Ref; Planning Application BE/60/15/PL

To be discussed at the Development Control Committee Meeting 23rd September 2015

Dear Councillor

Title:-
Proposed Site Plan

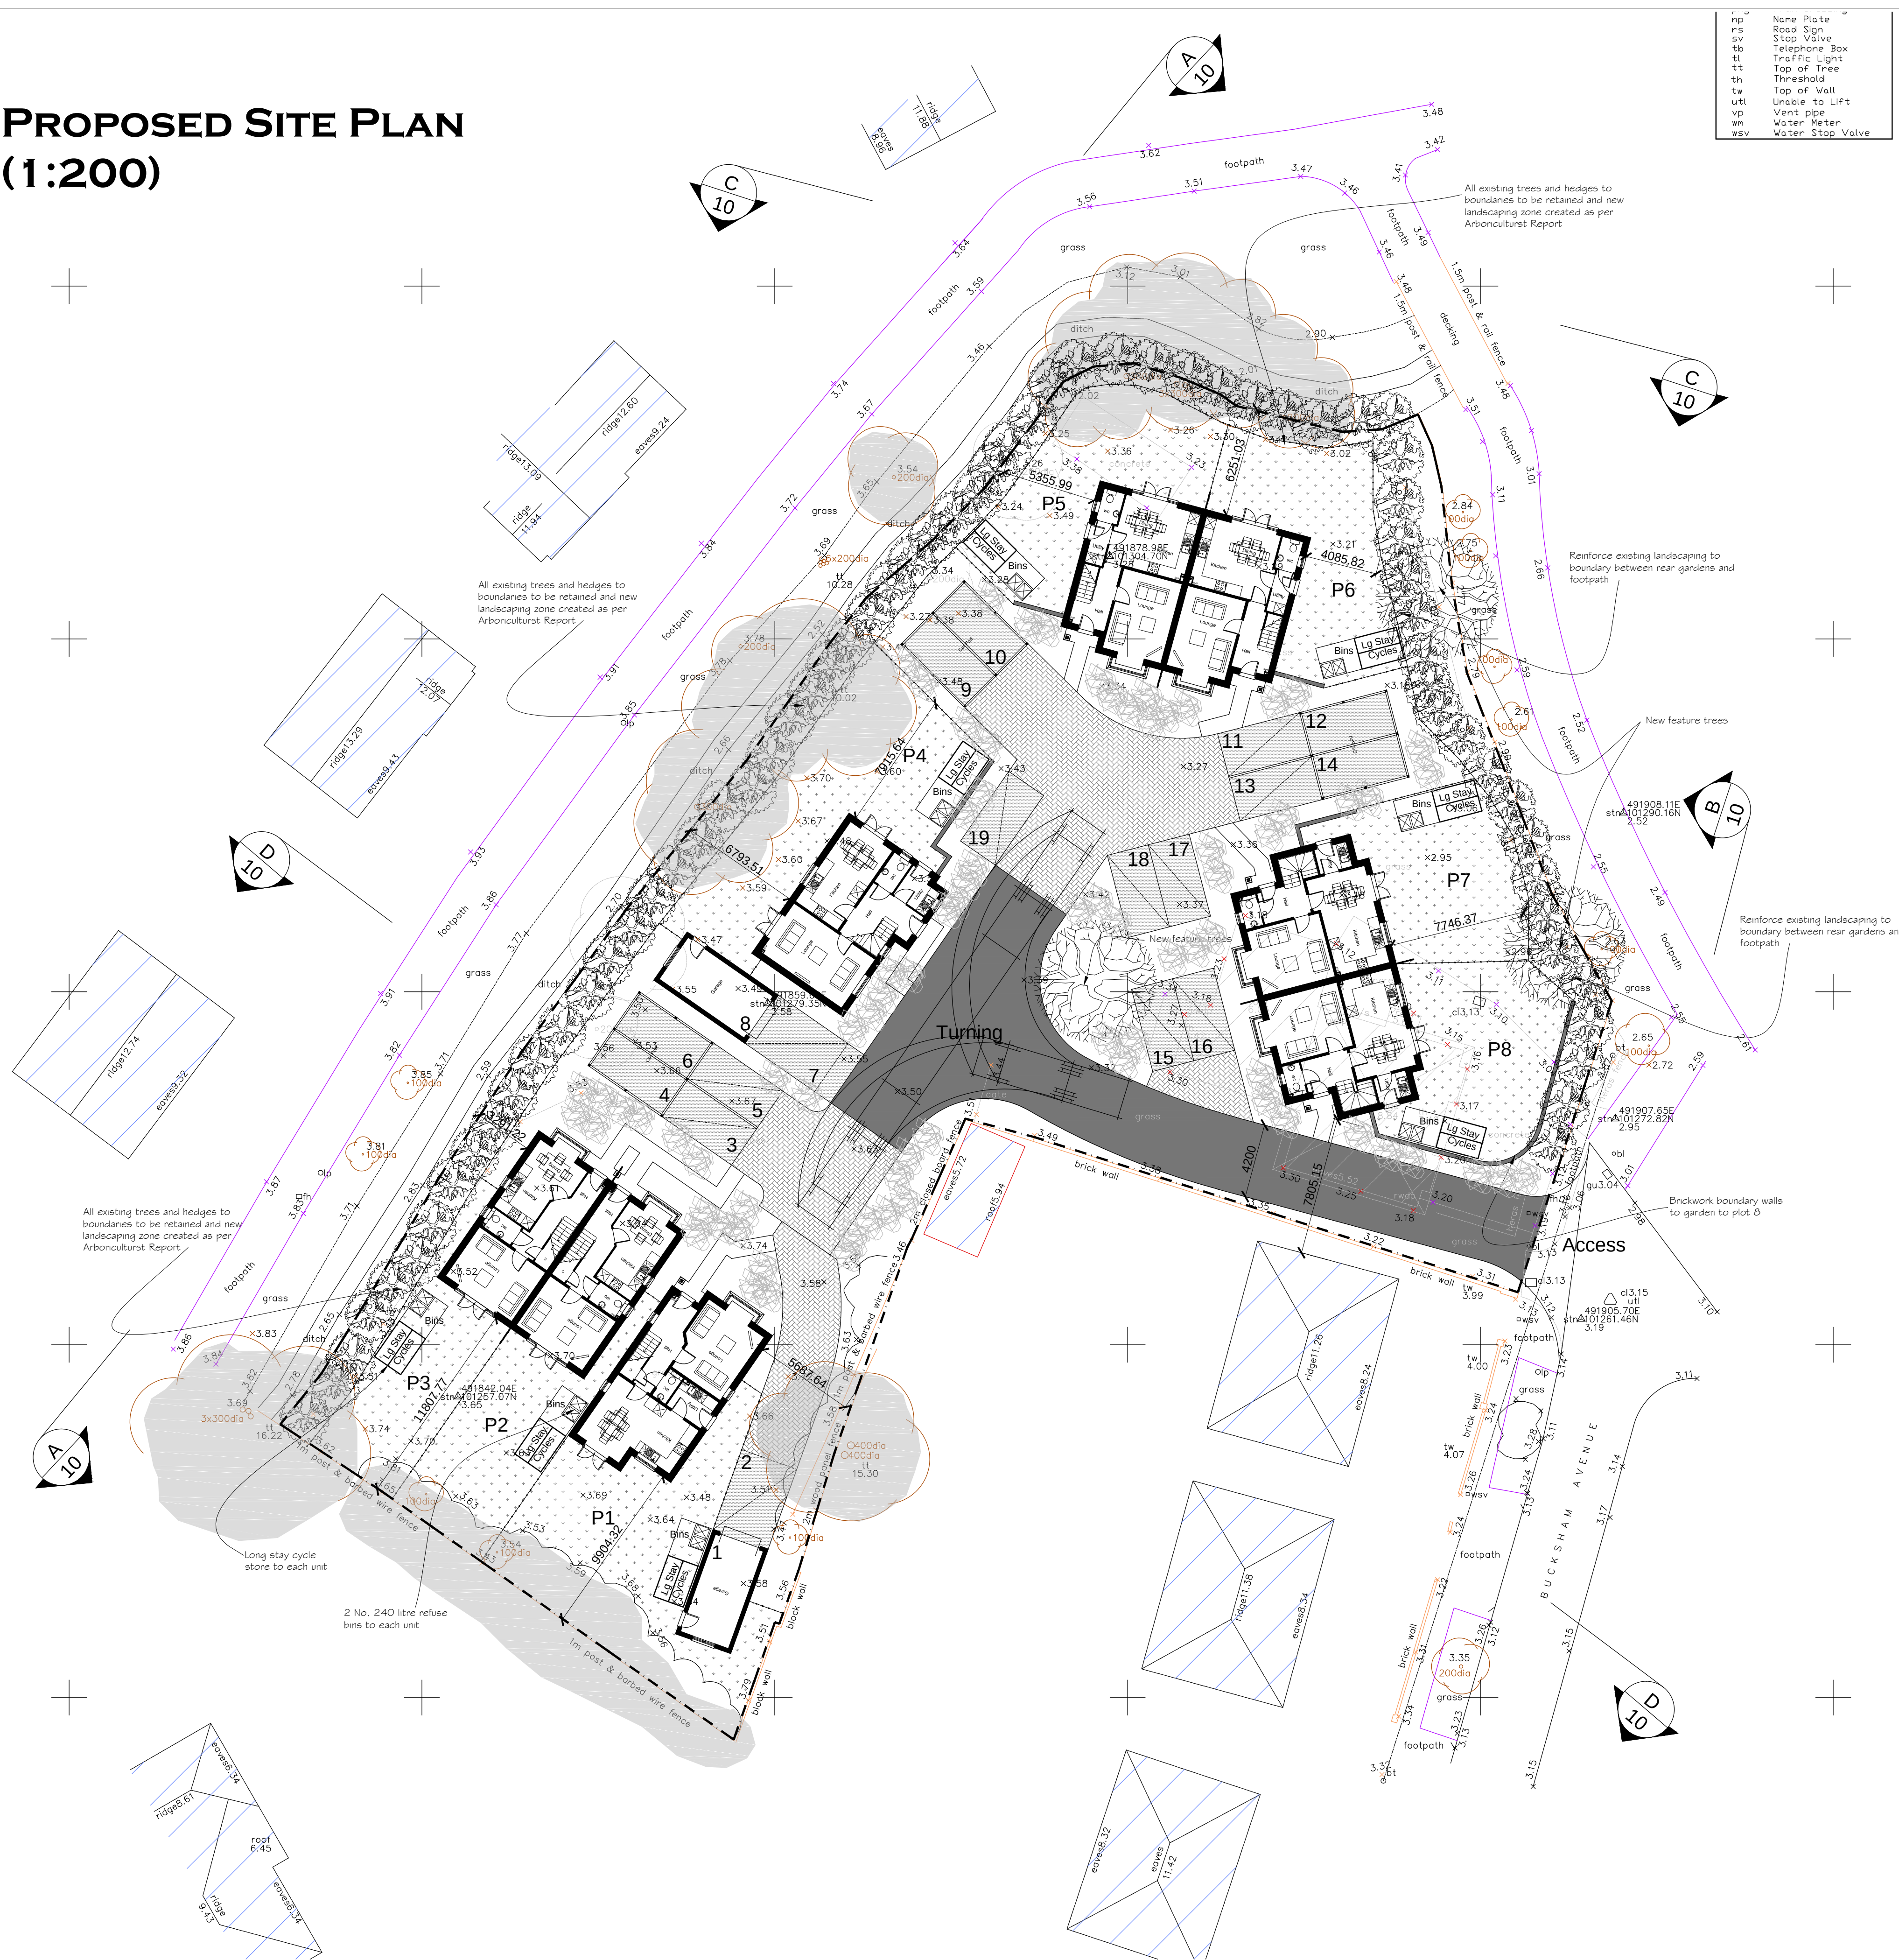
Where, as in this case, this is unachievable the proposals must conform to paragraph 11.2 where vehicle access must be within 45 metres of all points of a dwelling house. In this case this is in the first floor south west corner of plot 3. In actual fact this is in excess of 50 metres direct travel distance from outside the existing 17 and more than 55 metres in actual travel distance. Therefore the access is wholly inadequate.

With the significantly revised block plan the proposals contain a number of further inadequacies with regard to policy GEN 7:-

- There is inadequate visitor parking, the previous 3 spaces have been reduced to 1 for 8 houses. (This contradicts the minimum parking requirement at the original pre-planning consultations and meetings of 2014/15).

- There continues to be no pedestrian path into the site which, with plots 7 & 8 now discharging cars directly onto the access road significantly increases the danger to both pedestrians and vehicles. This has previously been objected to by Bersted Parish Council in the original layout. (This contradicts the safety considerations given to this access road at the original pre-planning consultations/meetings of 2014/15).

- There is unacceptable noise and disturbance to 15 & 17 by the changed vehicle parking and manoeuvring to plots 7 & 8.
- The first floor windows comprising bedroom 3, landing and bathroom of plot 8 over look existing numbers 15 and 17. These properties are occupied by the vulnerable elderly and young families. The windows are unneighbourly, directly compromise the privacy of these residents and would form an unsatisfactory backland development which would harm the privacy and quiet enjoyment of these neighbouring properties.

- Unless the applicants can use the part of the ADC drainage ditch adjacent to plots 7 & 8 then the garden for those plots provides insufficient garden space and private amenity for any occupants of those plots. Additionally the ditch forms part of flood zone 3b which, according to NPPF guidance, prohibits any form of domestic dwelling on that land.
